From: Martyn White <Martyn.White@arun.gov.uk>
Sent: 31 January 2020 17:18
To: Maria Tomalova <Maria.Tomalova@arun.gov.uk>
Subject: Y/105/19/PL & Y/106/19/L

Y/105/19/PL & Y/106/19/L

The proposal is for the conversion of, and alterations to, existing barns to create 3 dwellings, along with the erection of car barns, a store, a replacement pump house, demolition of a C20 barn and associated landscaping and parking.

Stakers Farm, Yapton

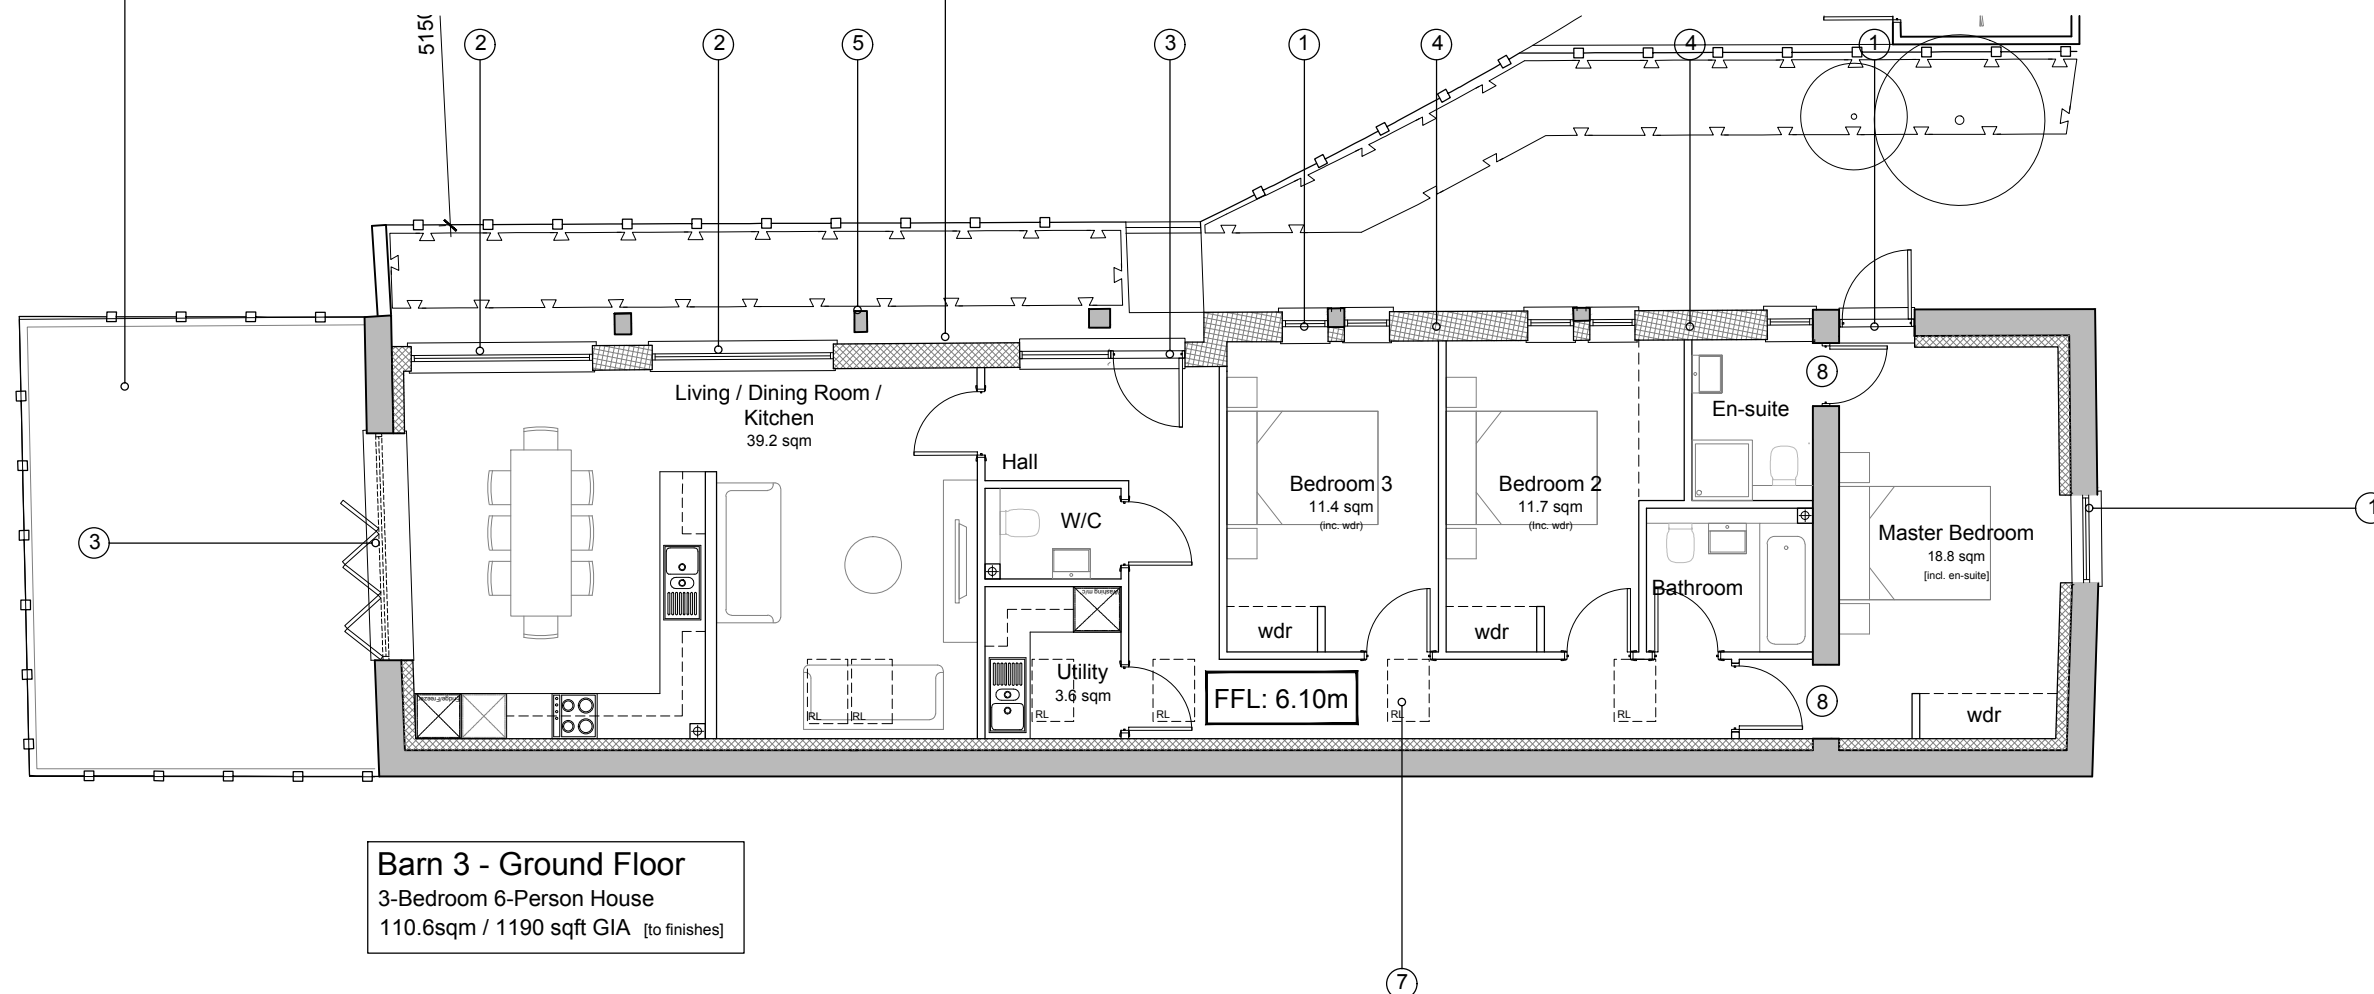
Likewise, in building one, it is noted that an elevation will be altered in order to expose the previous cart barn openings. Such a proposal is generally acceptable, but the design of the new elevation, which includes excessive amounts of glazing, should have a simple framed emphasis and be recessed as far as possible to allow a deep shadow line. Such an approach also minimises reflections to reduce the visual prominence of the glazing. This technique can also help to maximise light penetration into the interior. Details of the fenestration along this section of the elevation should be carefully considered in order to ensure that they do not dominate the elevation.

It is noted that the proposals will generally utilise existing openings for windows and doors. Such an approach is positive. However, it is noted that existing doors (or replacements) are not to be incorporated as part of the final scheme. This is unfortunate, as they retain character as part of the building, and are reminders of previous use. Where doors remain, they can be retained and used as shutters; doors can be fixed open in order to ensure that enough light is available to the interior of the building. If in a poor state of repair, they can be repaired or replicated.

There is some concern regarding the amount of rooflights proposed. Are so many necessary?

It is not fully clear what the proposed joinery will look like. It is recommended that they should not be stock doors/windows from a joinery catalogue as these are generally too "domestic" in style, and out of character with the original purpose of the building. As mentioned, glazing and frames should be deeply recessed in order to reduce reflections and visual impact.

Likewise, it is noted that the building referred to as 'barn 3' is to include bi-folding doors. Such a feature is not normally associated with a barn and cannot be supported here. It is suggested that an alternative approach be considered which would result in the loss of less historic fabric, and a more appropriate design.
